Appeal Decision

Appeal Ref: 6001414

6 North Avenue, Hillingdon, Hayes, UB3 2JE

DRAWING TITLE:
Proposed
Loft floor
Plan

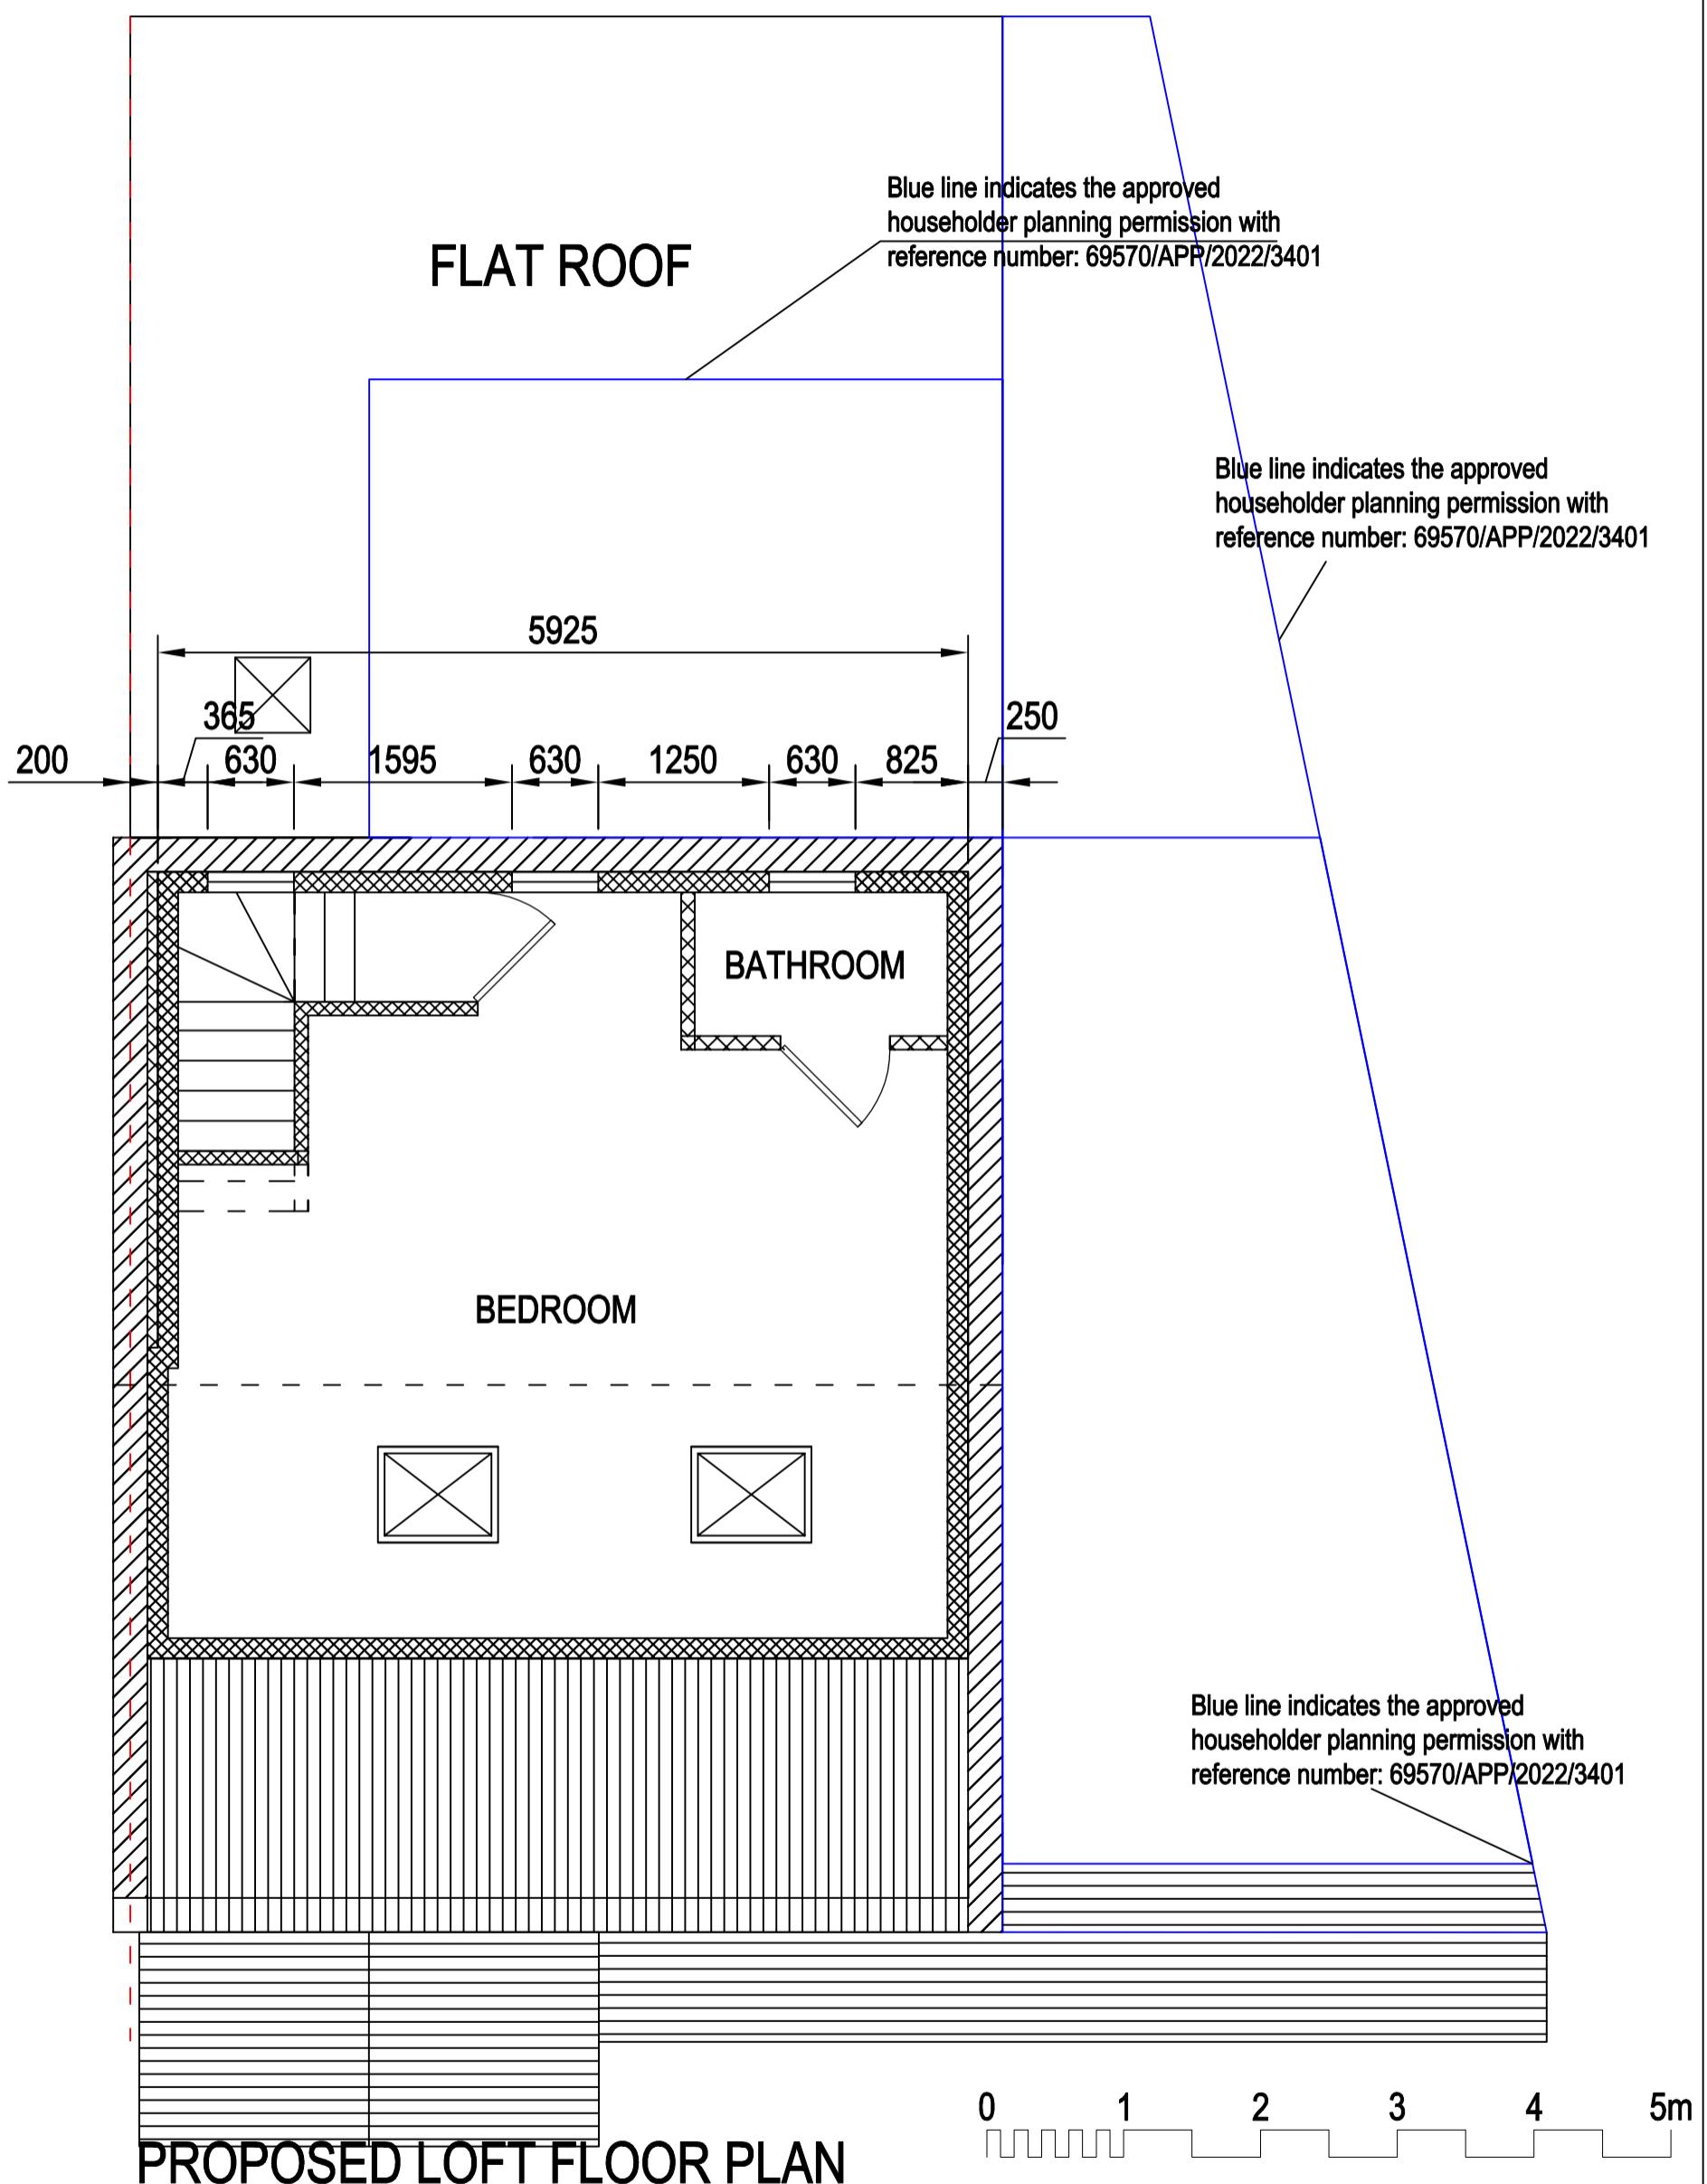
7. The proposed rear dormer would occupy over two thirds of the roof. Whilst it would be set down from the original roof ridge, in from the sides and up from the eaves in accordance with policy DMDH1 of the Hillingdon Local Plan: Part Two – Development Management Policies (HLP2), these set ins would not mitigate its occupation of a large part of the roof. Furthermore, although the dormer would not be readily visible from North Avenue, it would be apparent from the public realm between dwellings on Orchard Road as well as by the occupants of adjacent private neighbouring properties. The dormer would as such appear as a dominant addition to the host dwelling and wider terrace, eroding the legibility of the original roofscape and undermining both the uniformity and visual quality of the area.

Proposed Elevations

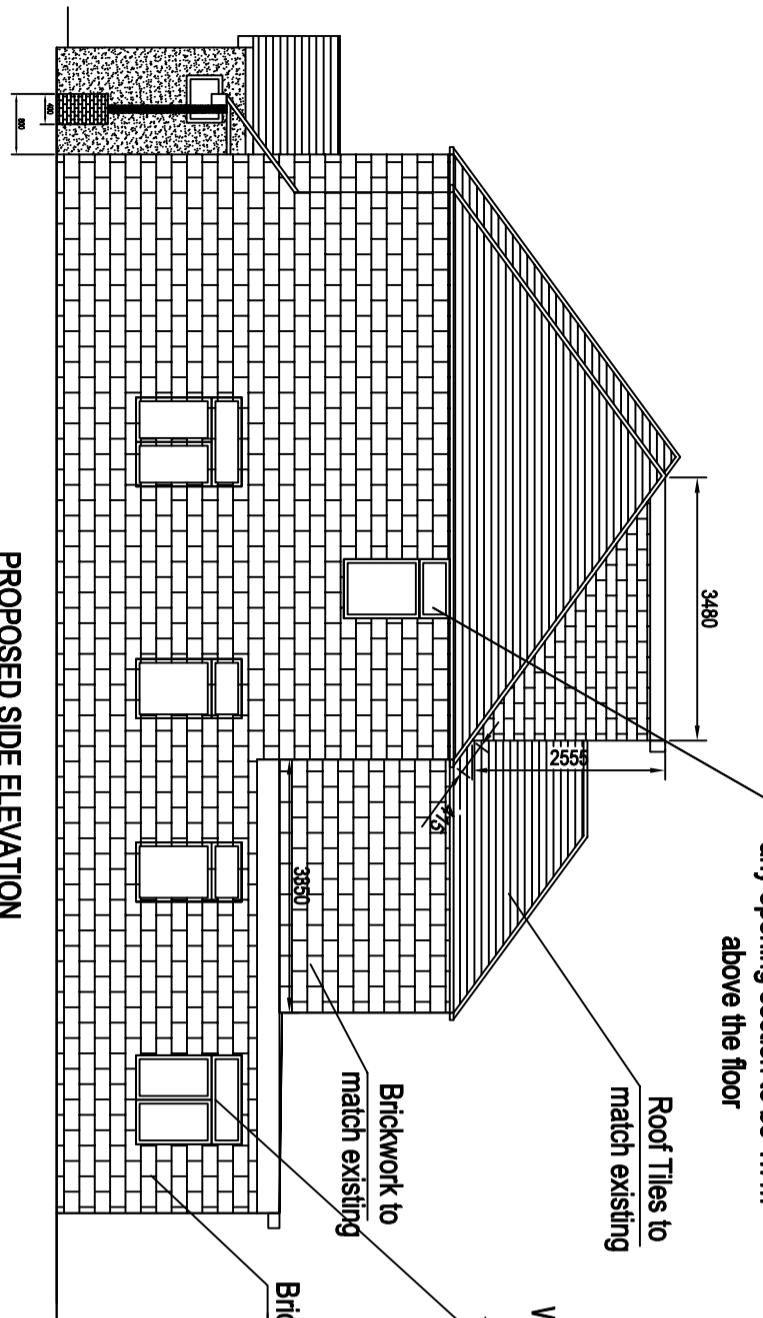
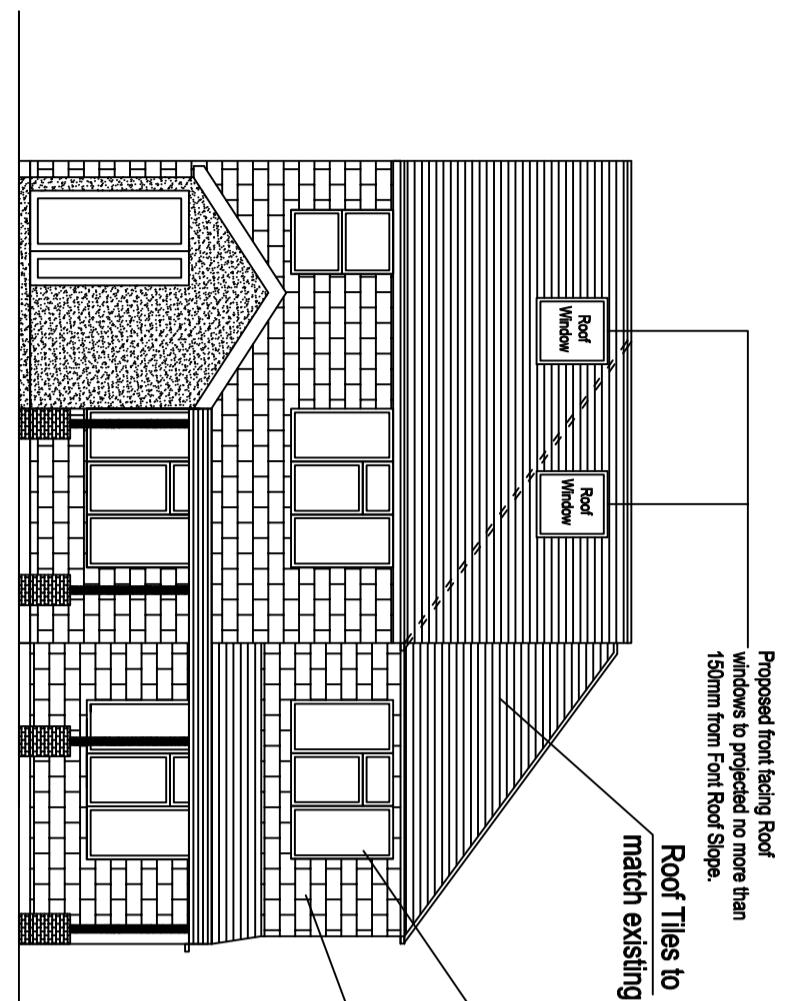
6. The hip-to-gable roof extension would result in a gable end wall being formed to the site of the existing house. This would lead to the hipped roof of the side extension. Although a hipped roof would be retained, it would be connected to the gable wall of the host and the strong lines of the existing roofscape would be eroded. The loss of this legibility and the introduction of a gable wall would result in the roof

extension appearing as substantial additional bulk to the host dwelling. This would fail to integrate satisfactorily with the existing terrace.

8. Policy DMHD1 of the HLP2 sets out that front extensions should be minor and not alter the appearance of the house, and those extending across the entire frontage will be refused. The portico and porch would stretch the full width of the dwellinghouse, inclusive of the side extension. By virtue of its extent and design with fussy portico features and lack of rhythm of the windows, it would appear as a substantial and incongruous addition to the host dwelling.
